Mark E. Jones, PE
Structural Engineering and Design

Ref: Site Observations and Analysis
60 Warner Hill Ct.
Fuquay-Varina, NC 27526
Project No. 24-129

FIRST FLOOR PLAN
SCALE: 1/4"=1'-0"
9'-0" CLG. HGT.
SET WINDOWS AT 7'-10" A.F.F.

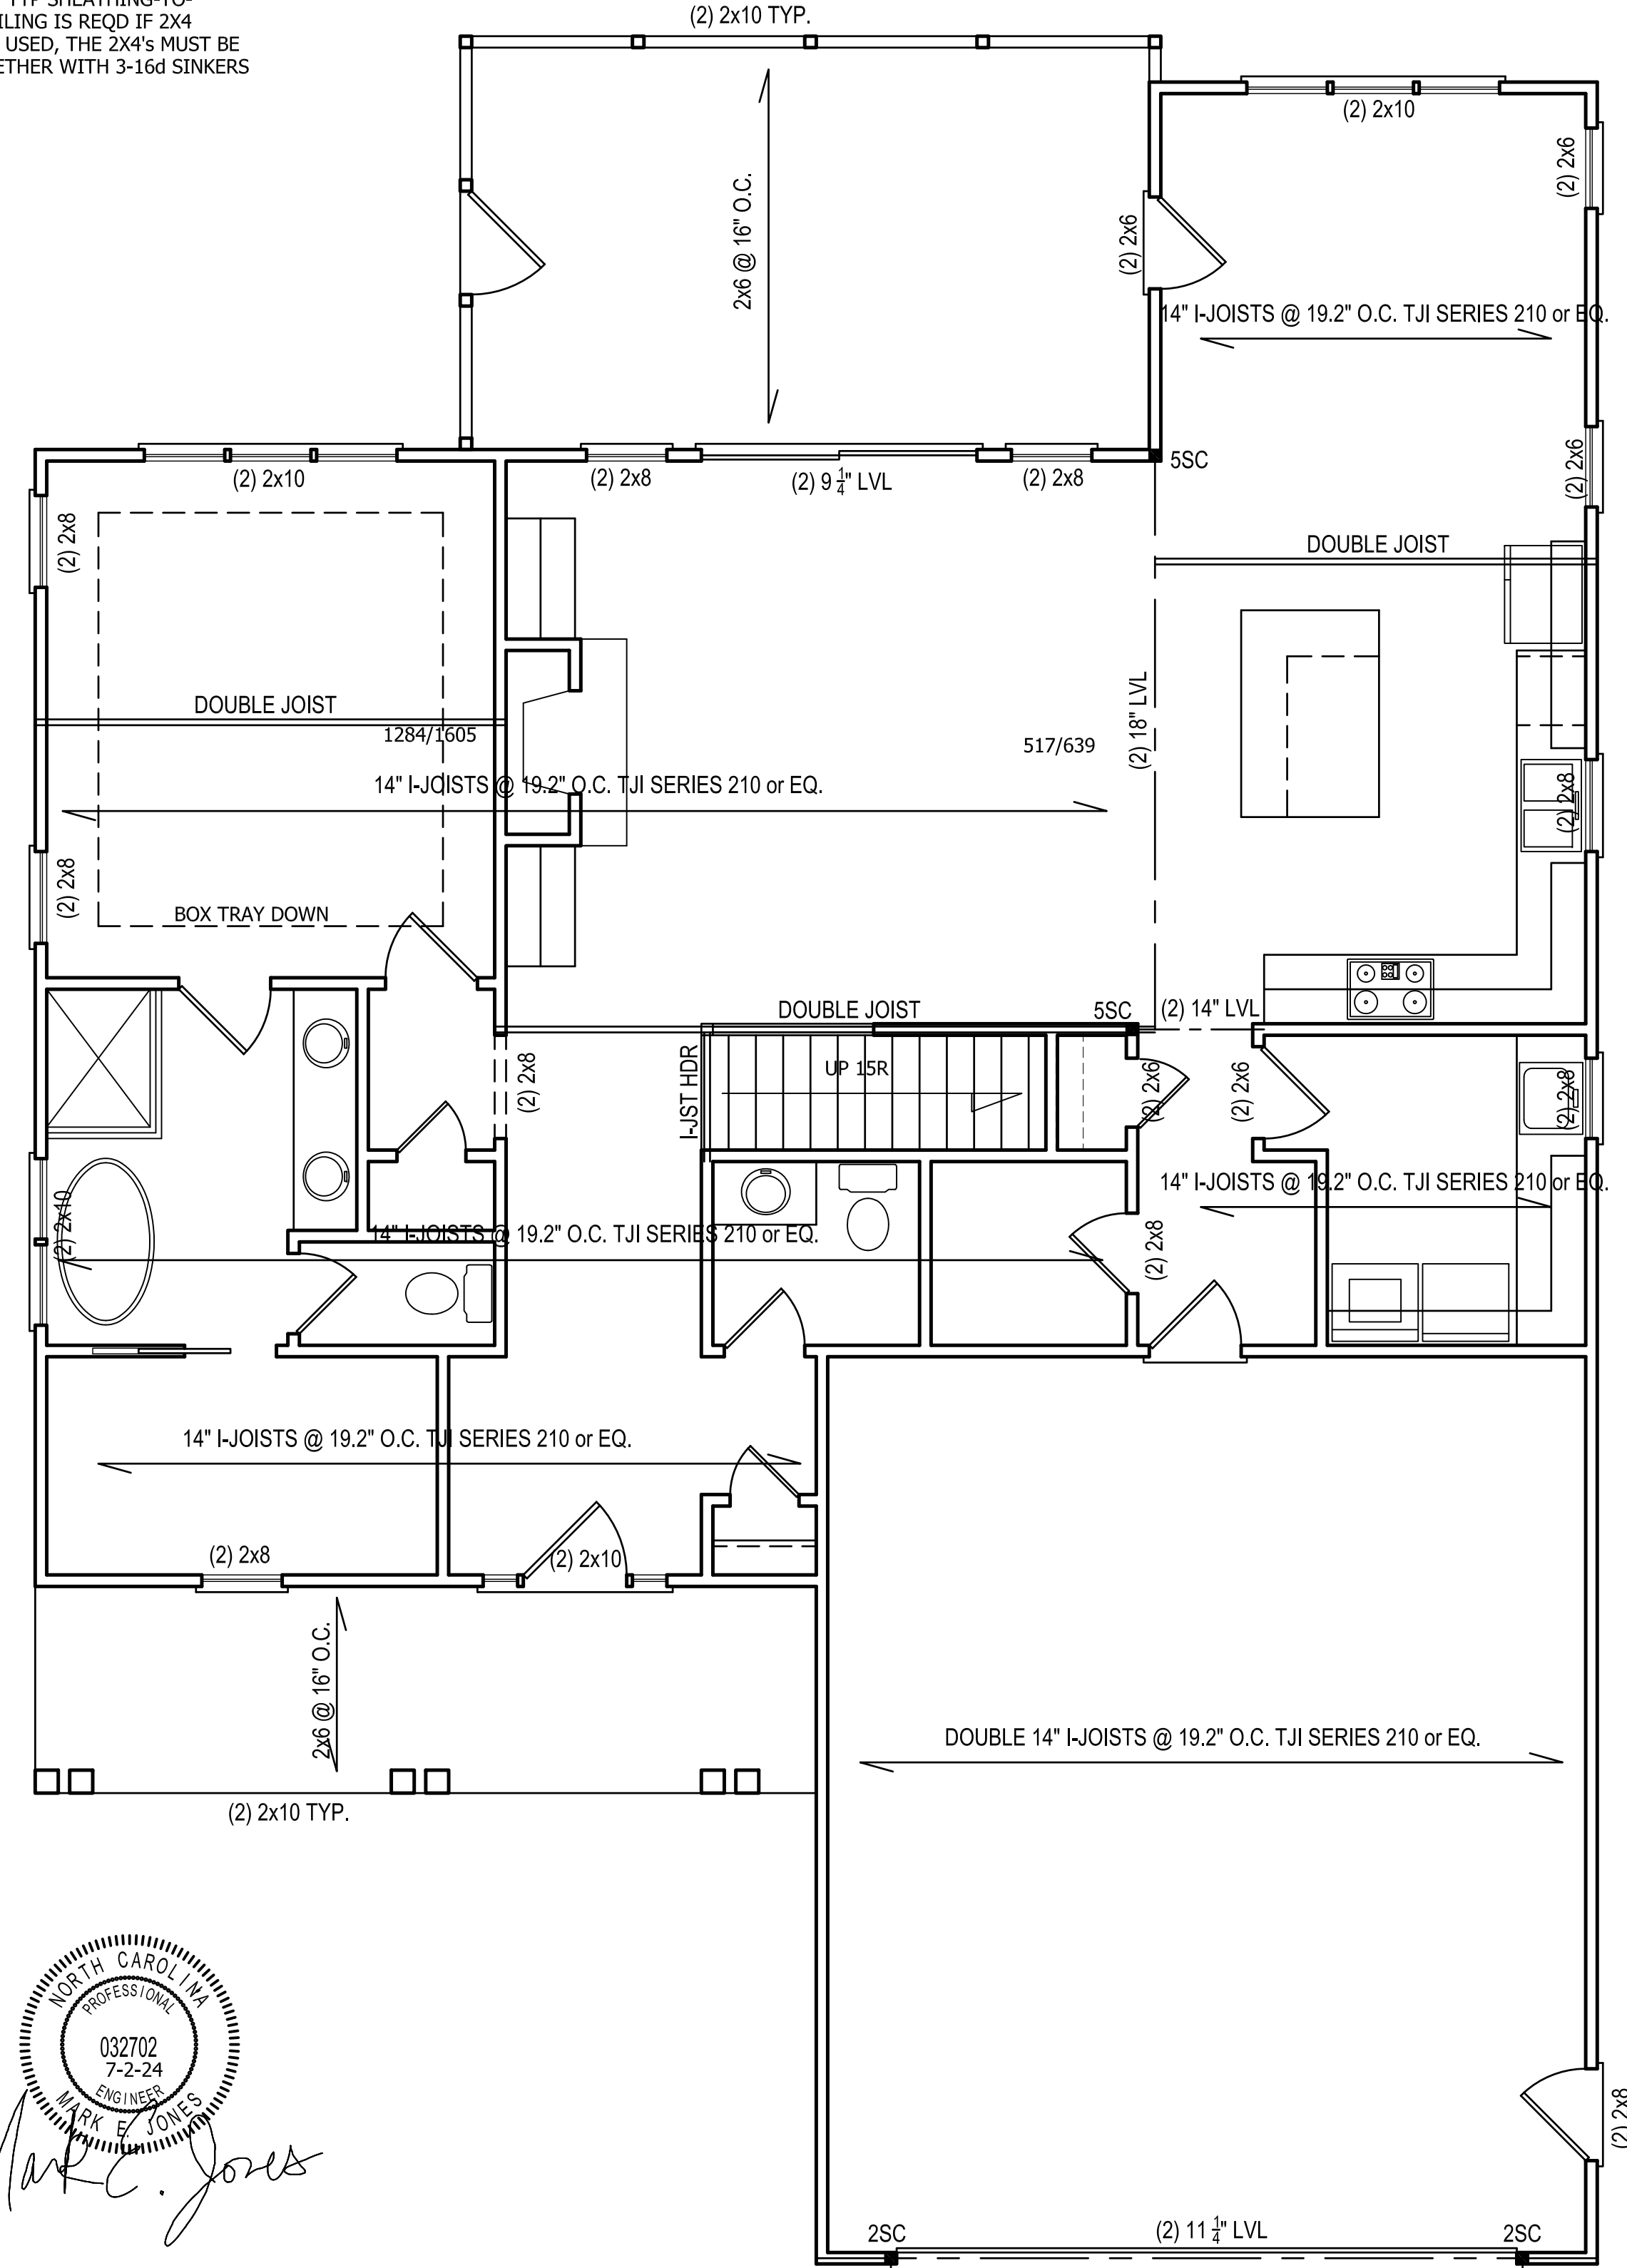
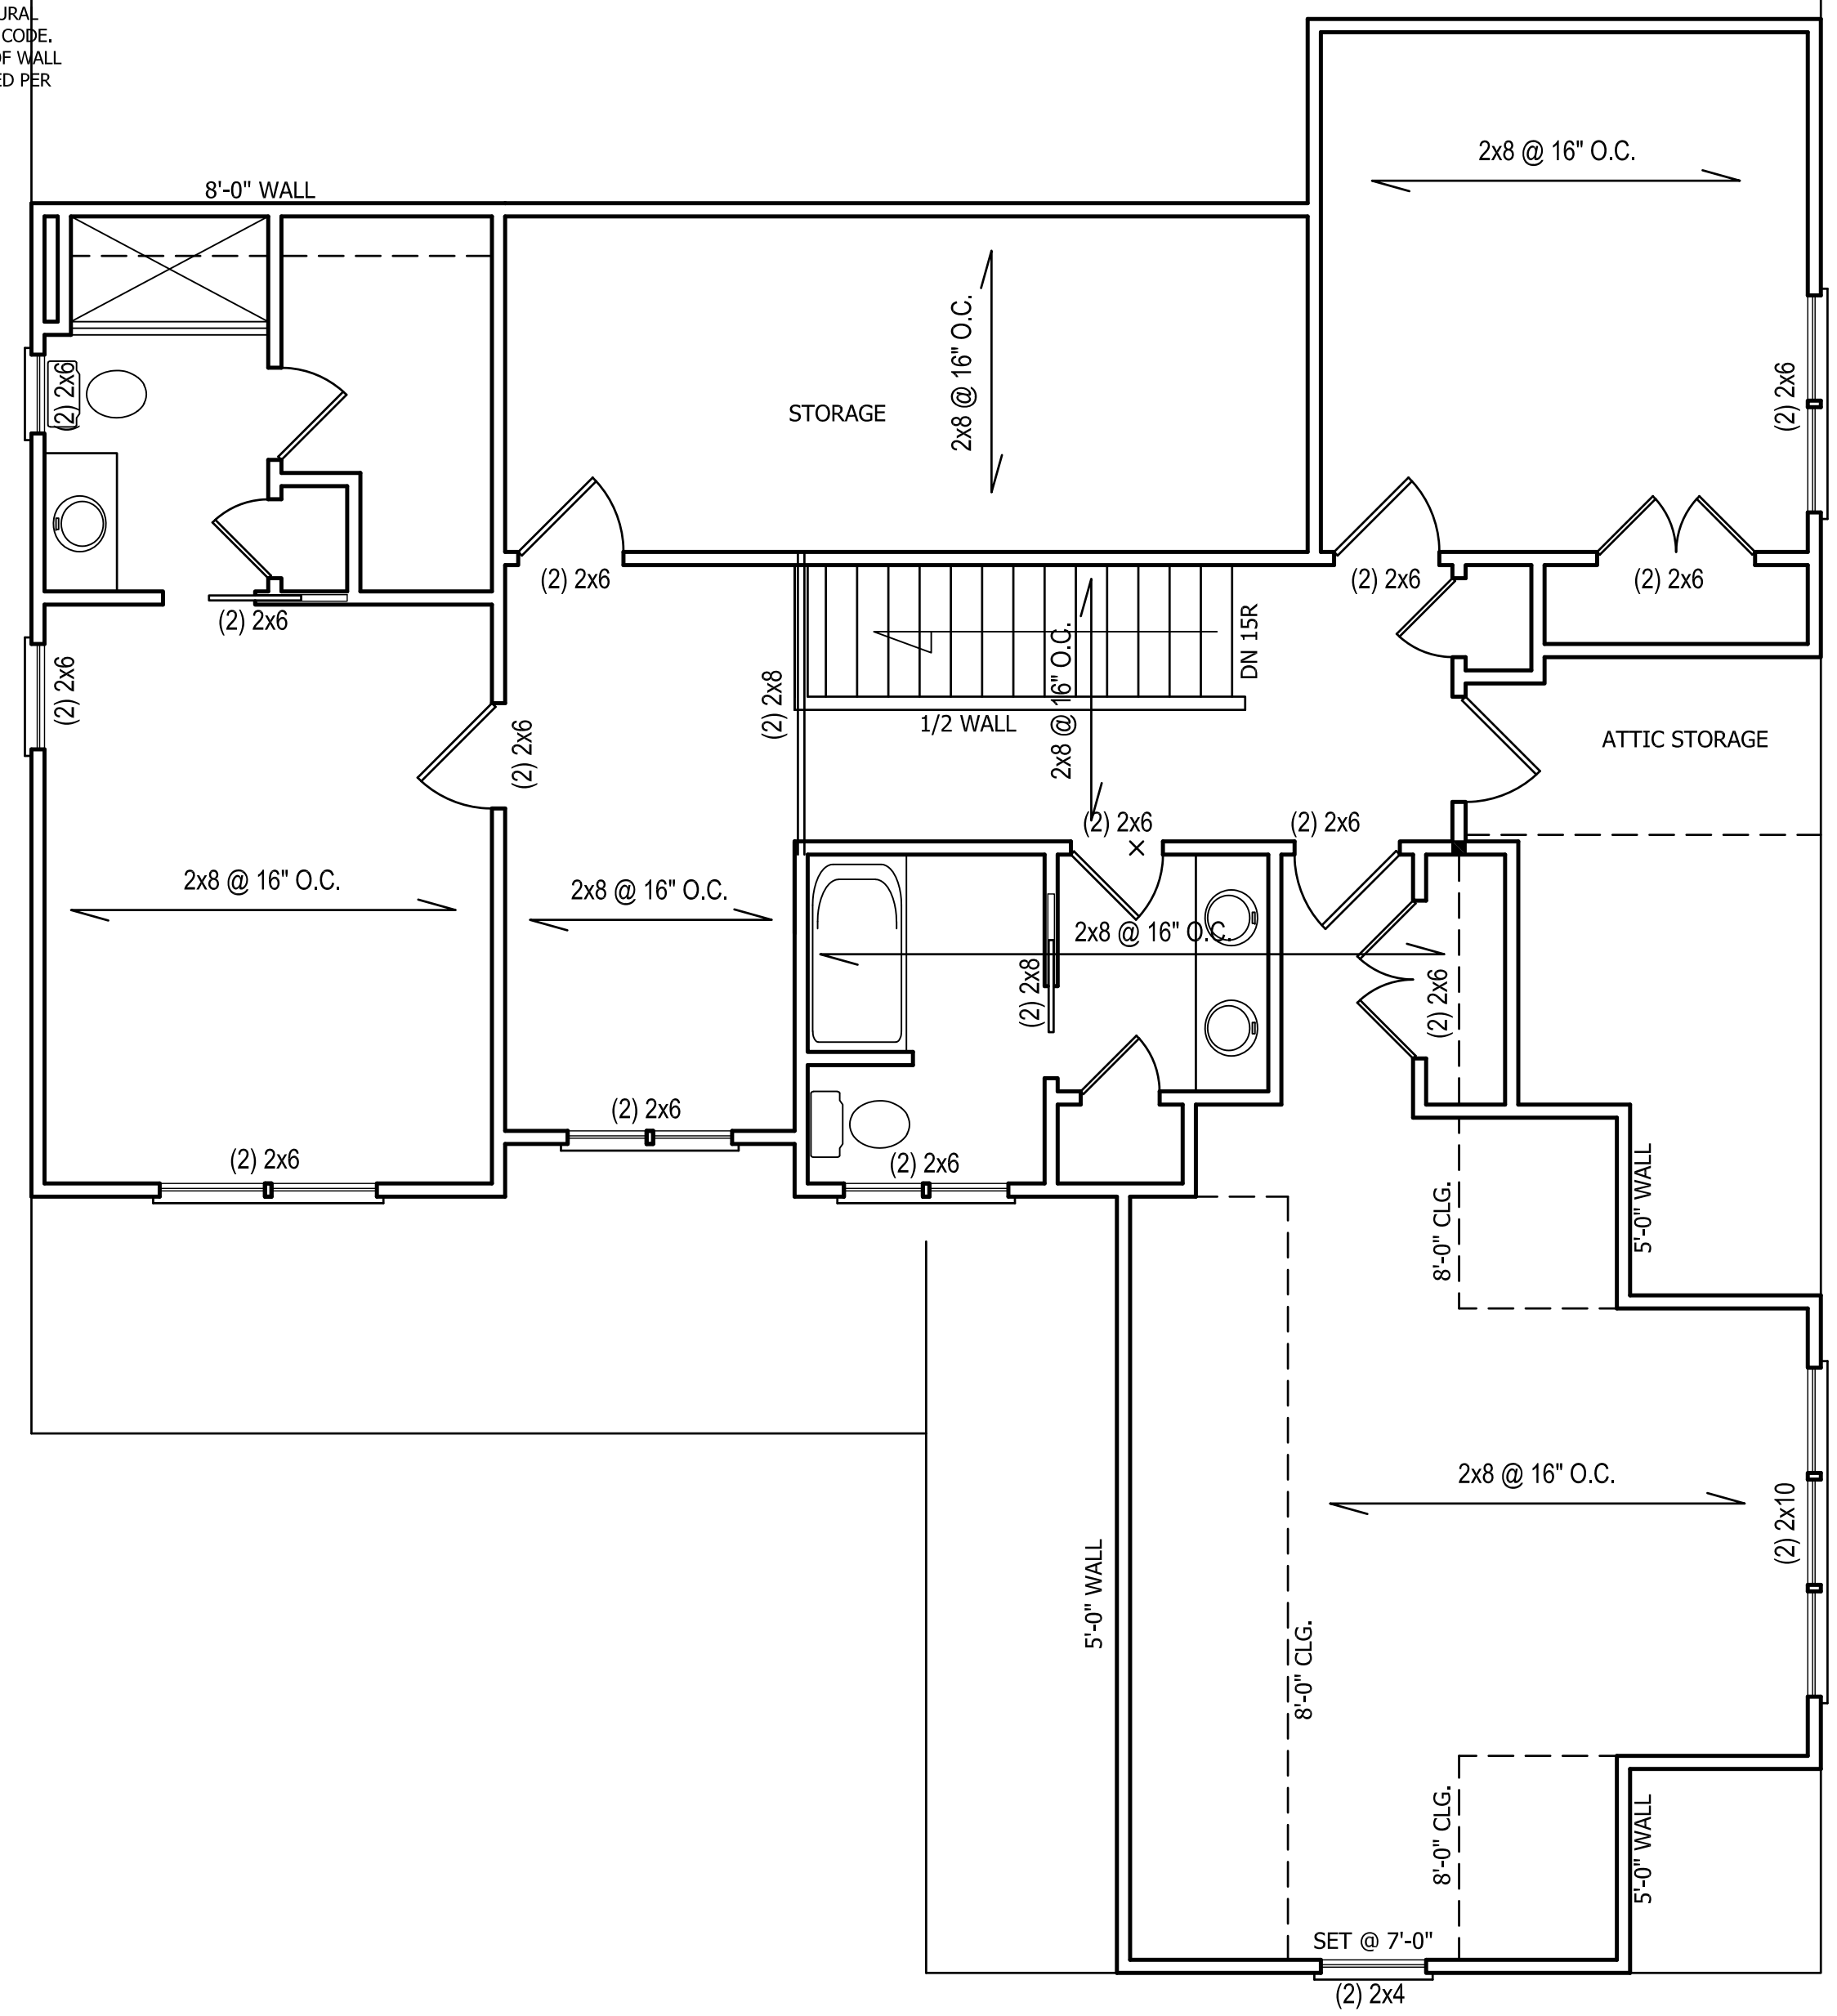
3. Broken floor joist in the living room.

3. The builder shall install osb fillers in the web of the I-joist to be flush with the flanges.
A 48" long 2x4 shall be installed on each side of the bottom flange at the end of the joist.
A 2x block or a 3" framing angle shall be used to attach the new 2x4s to the beam.
